**GL INVESTMENTS COMPANY**

**161 SUSSEX STREET**

**S96 (3) ACCESS REVIEW**

**Morris Goding Accessibility Consulting**

Drawing Title GROUND LEVEL FLOOR PLAN		
Drawing Number A-DA-0201	REV. O	
Scale 1:200 @ A0

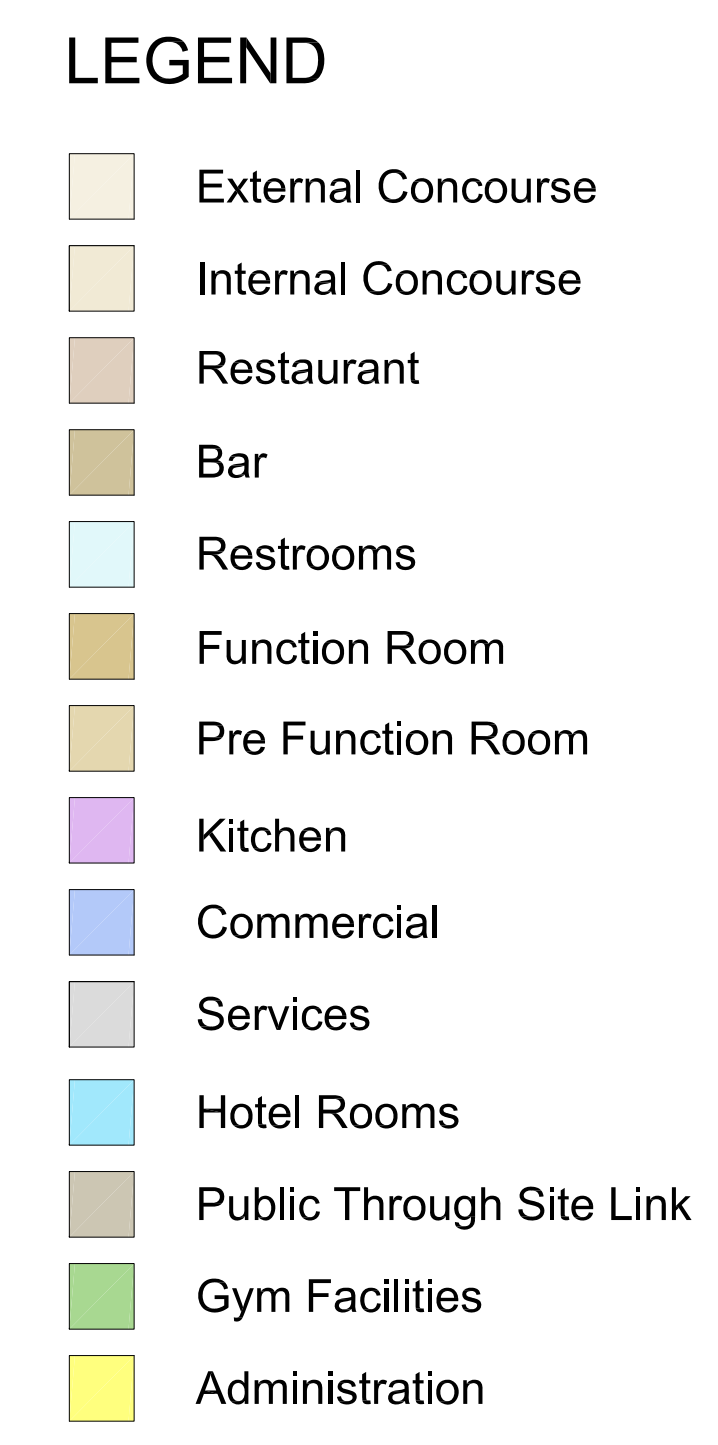
The previously approved through site link to connect Sussex Street to Darling Harbour in line with the Director General Requirement will be maintained and improved for access. The new link is comprised of a series of 3 x accessible ramps that connect the split-level ground and upper ground level (approx. 1.5m height variation) along southern side of the Hotel Lobby.

The ramps can achieve suitable 1:14 gradients, lengths and landings, compliant with AS1428.1:2009. This will be developed at design development stage to ensure suitability.

This application proposes to demolish the existing through site link stair to Wheat Road and replace it with a new public stair in a similar location. The stair is located between the distributor over/under pass areas and public domain area, outside of the project site boundary. While the stair will not be accessible to wheelchair users, with the provision of suitable features it can provide safe access to people with ambulant and sensory disabilities. As such it will improve the current level of access provided by the existing stair, which is non-compliant with AS1428.1:2009.

- (i) Ensure new public stair is suitably recessed at top and base landings and provides handrails on both sides and access features, compliant with AS1428.1:2009.
- (ii) Ensure through-site link access ramps walkways have gradients no steeper than 1:14 with suitable level landings and design in accordance with AS1428.1:2009.

There is a covered, on-grade accessible path of travel around the Porte-Cochere, leading to the Hotel Main Entry and the adjacent Convention Entry, at ground level from Sussex Street. The pedestrian access-ways leading to the entry points can achieve gradients, suitable for people with disabilities, compliant with AS1428.1:2009. The proposed floor surfaces will be developed at design development stage to ensure suitable access features near building entrances and on-grade roadway surface, to assist people with vision impairment.

The staff entrance, at ground level is in close proximity to Convention and Hotel Main Entry. There is an accessible path of travel to this entry around Porte-Cochere or via Wharf Lane bridge that is suitable for people with disabilities.

The staff entry airlock, leading to internal stairs (fire stair 18) is not accessible to wheelchair users. However the proximity of adjacent Hotel entrances (within 25m distance) provides an alternative accessible entry for staff members that may require use of a lift to satisfy the DDA Premises Standards. At design development stage, access to Hotel sign in areas, for staff members with disabilities using the accessible entry will be addressed in consultation with the Hotel. This is achievable.

Within the Hotel at ground level there is an existing split-level (approx. 1.5m height variation) between the entry level Lobby and upper ground level where All Day Dining Area/Restaurant and Function Meeting Rooms are located (along western side).

At south end of Lobby an accessible path of travel is provided by the through site link (1:14 ramps) and main stairway that will be designed in accordance with AS1428.1:2009. At north end of Lobby an accessible path of travel is provided by a combined passenger/goods lift and a 1:14 ramp. In addition, there are public stairs that will be designed in accordance with AS1428.1:2009.

Additional level changes at ground level will be addressed by various stairs and alternative 1:14 ramps and 1:20 walkways that can achieve compliance with AS1428.1:2009. In general, access to and within all common-use Hotel/Function areas at ground level, including: Lobby, Reception, Bar, Dining, Buffet, Lounge, Bridge Link to Heritage Central warehouse building, Sanitary facilities, Meeting Rooms, suitable for people with disabilities can be achieved.

- (i) Ensure all 1:14 ramps and stairs have handrails on both sides and are suitably recessed top and base, compliant with AS1428.1:2009.
- (ii) All common-use doors to provide 850mm clear width active leaf with suitable door circulation areas and operation, compliant with AS1428.1:2009.
- (iii) Due to the increased size/weight of acoustic doors to meeting/Function areas, power automated doors with accessible controls may be required, compliant with AS1428.1:2009.
